Fw: 3 Holme Close Hatfield AL10 9LQ - Proposed single story extension Daylight and Sunlight Matters

Application reference: 6/2019/0102/PN8 of 21st Jan 2019.

**3 Holme Close Hatfield AL10 9LQ
Daylight and Sunlight Matters**

Application For "Prior approval for the erection of a single storey rear extension measuring 6m in depth, 3.1m in height and 3m to the eaves"

| Proposed Right & Left Elevation | YB |

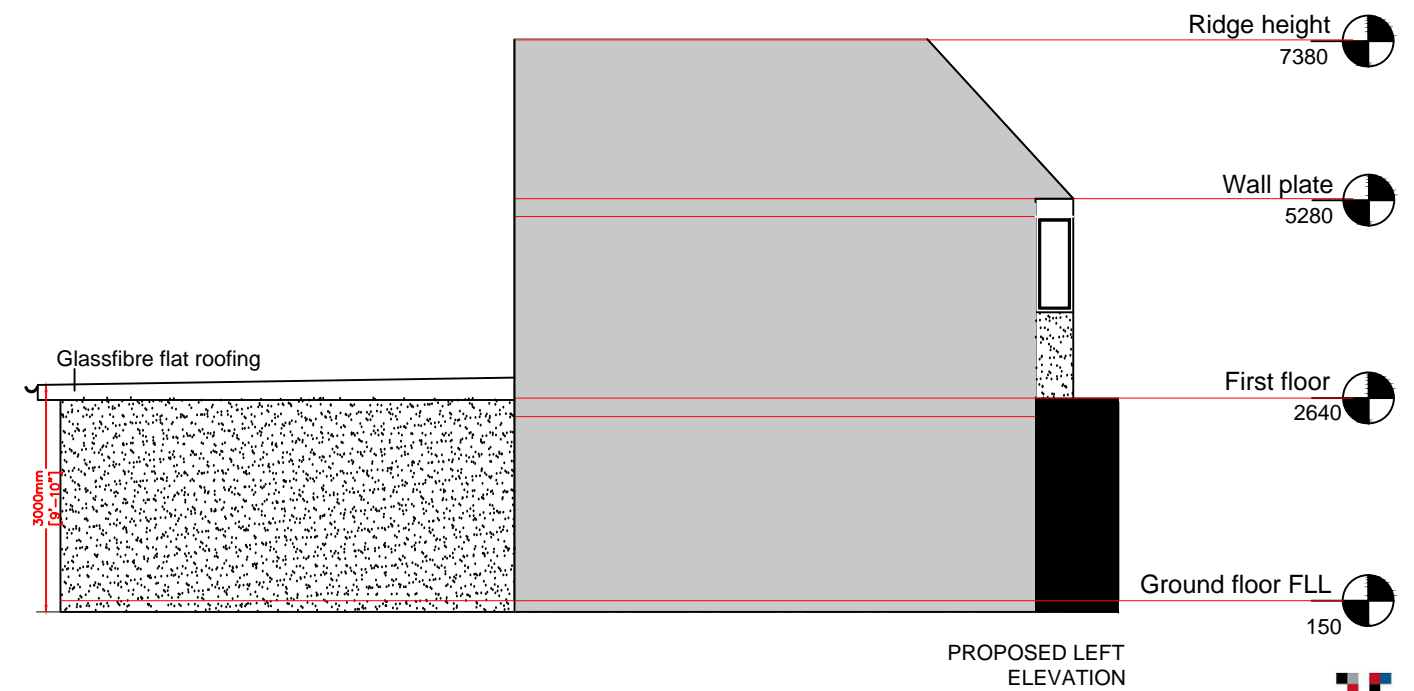
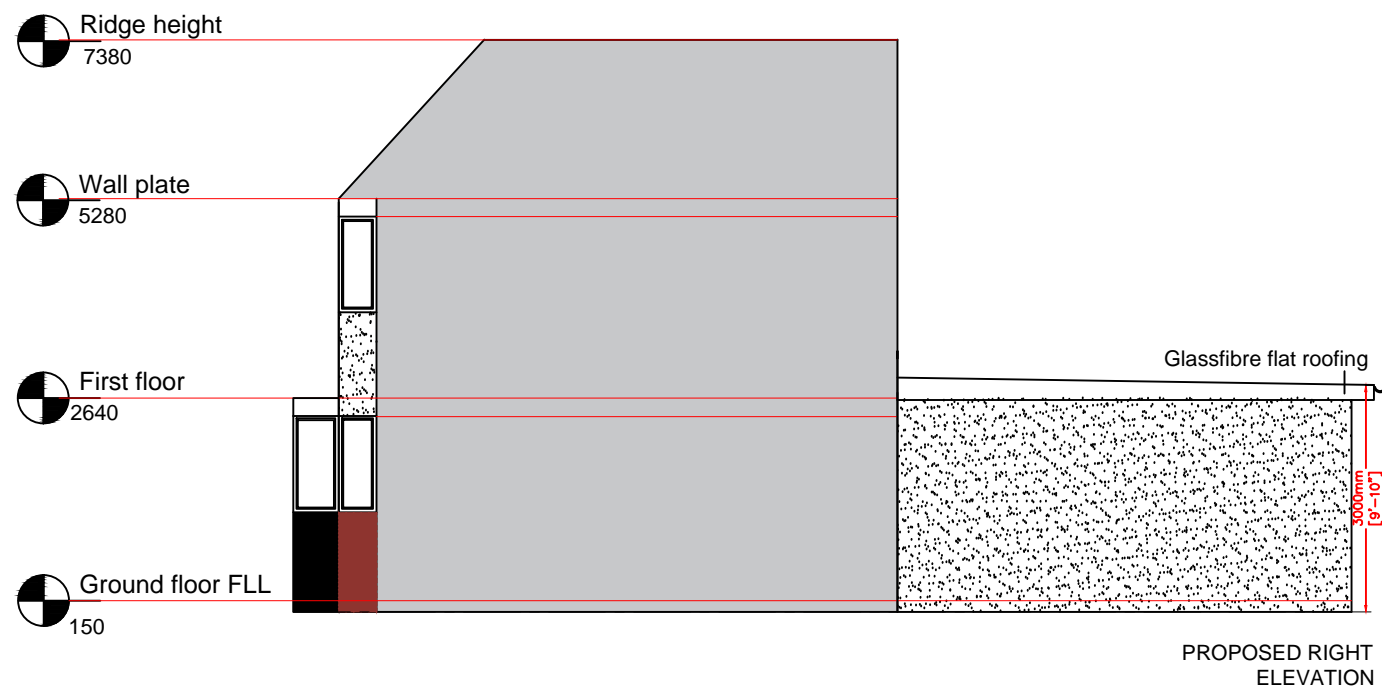
Looking at the proposed plans, I note that the maximum height is given as 3.1 metres.

I also understand the maximum height allowed is 3m only. I also would like the applicant to verify if the height given is from existing patio level, which is higher than ground level, or from original ground level as I believe the height has to be measured from the highest point of the natural surface ground adjacent to the development.

With reference to the applicant's plans and the attached photographs at Appendix 1, it can be seen that the proposed ground floor extension breaches the BRE 45° test as stated in 2.2.15 and figure 17 of the BRE document. The proposal will therefore have a material effect upon the daylight and sunlight reaching the ground floor principal kitchen window. This is the important window serving the kitchen sink and work surface where the important tasks are undertaken using sharp knives and food preparation.

The illustrations from the BRE guidelines confirm the principle that when the applicant creates his substantial 6m deep, 3.1m high extension, the kitchen main habitable window that receives direct daylight and sunlight. The daylight will be affected and the neighbour will lose afternoon sunlight from noon onwards.
